WEST SUSSEX COUNTY COUNCIL CONSULTATION

TO:	Arun District Council FAO: Silvie Steiningerova
FROM:	WSCC – Highway Authority
DATE:	24 September 2025
LOCATION:	Land West of Holly Drive Littlehampton
SUBJECT:	LU/184/25/DOC Approval of details reserved by condition imposed under LU/47/11/ relating to conditions 21-Ecological Management Plan, 22-Construction Method Statement, 23-details of construction compound and 26-Roads Construction Programme (see LU/185/25/DOC for approval of details reserved by condition imposed under LU/47/11/ relating to condition 10-surface water drainage). An amendment received to the above application dated 19th September 2025 relating to: Conditions 21, 22, 23 and 26.
DATE OF SITE VISIT:	n/a (desktop study undertaken – site visited previously)
RECOMMENDATION:	More Information Required

Comments below solely respond to conditions 22, 23 and 26 (found in Construction method Statement produced by Persimmon Homes Ltd., Revision 02, September 2025).

Dwg. No.	001.1.TVAL.0100	Rev	P1
----------	-----------------	-----	----

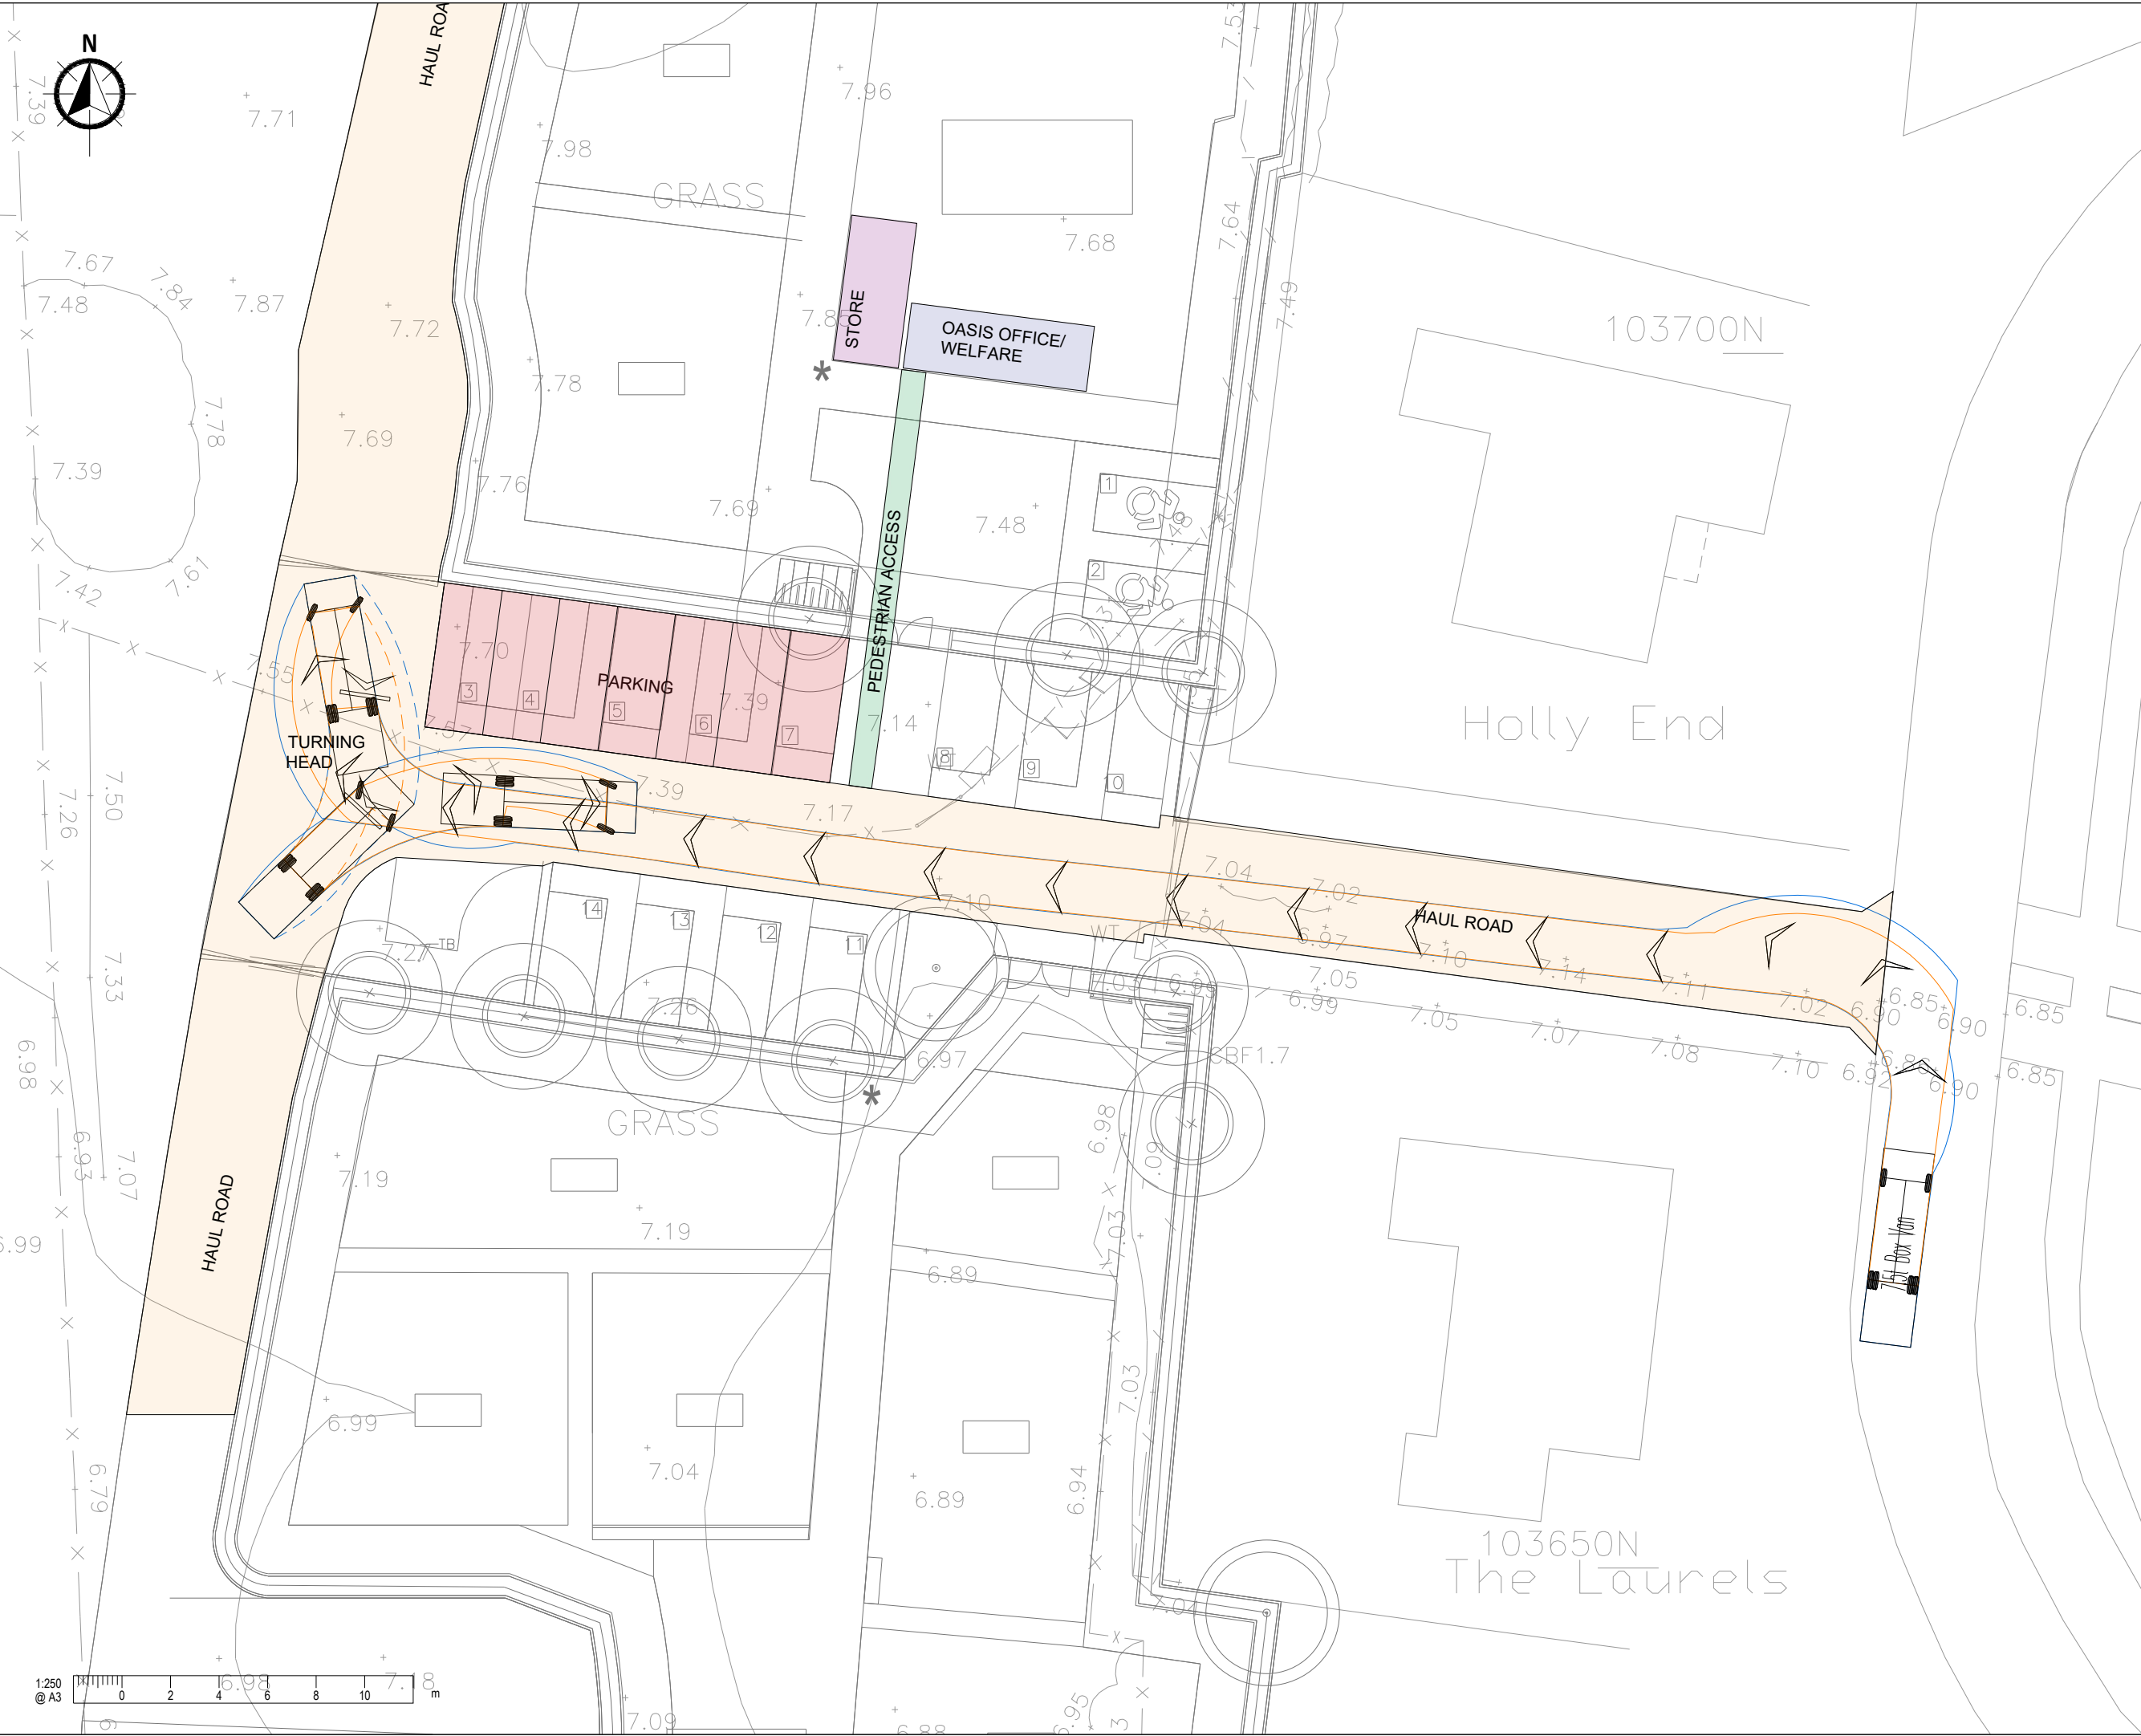
The applicant says that they anticipate no more than 30 Heavy Goods Vehicle movements will occur during a normal week. They continue by saying that all construction traffic will approach and leave the site using the Nightingale Way Access, via the roundabout from the Lyminster Bypass. Construction traffic will need to access the Bypass from the A259 Worthing Road access (south of the site) until the Northern section of the Bypass (Santa Monica Way) is opened. No construction traffic will enter and leave from Holly Drive. However, Drawing No. 001.1.TVAL.0100 P1 seems to show that vehicles will enter and leave using Holly Drive via Toddington Lane. As such, the applicant should clarify access routing arrangements by way of a further description (noting that the Lyminster by-pass is now fully open to traffic) and a plan showing routing arrangements.
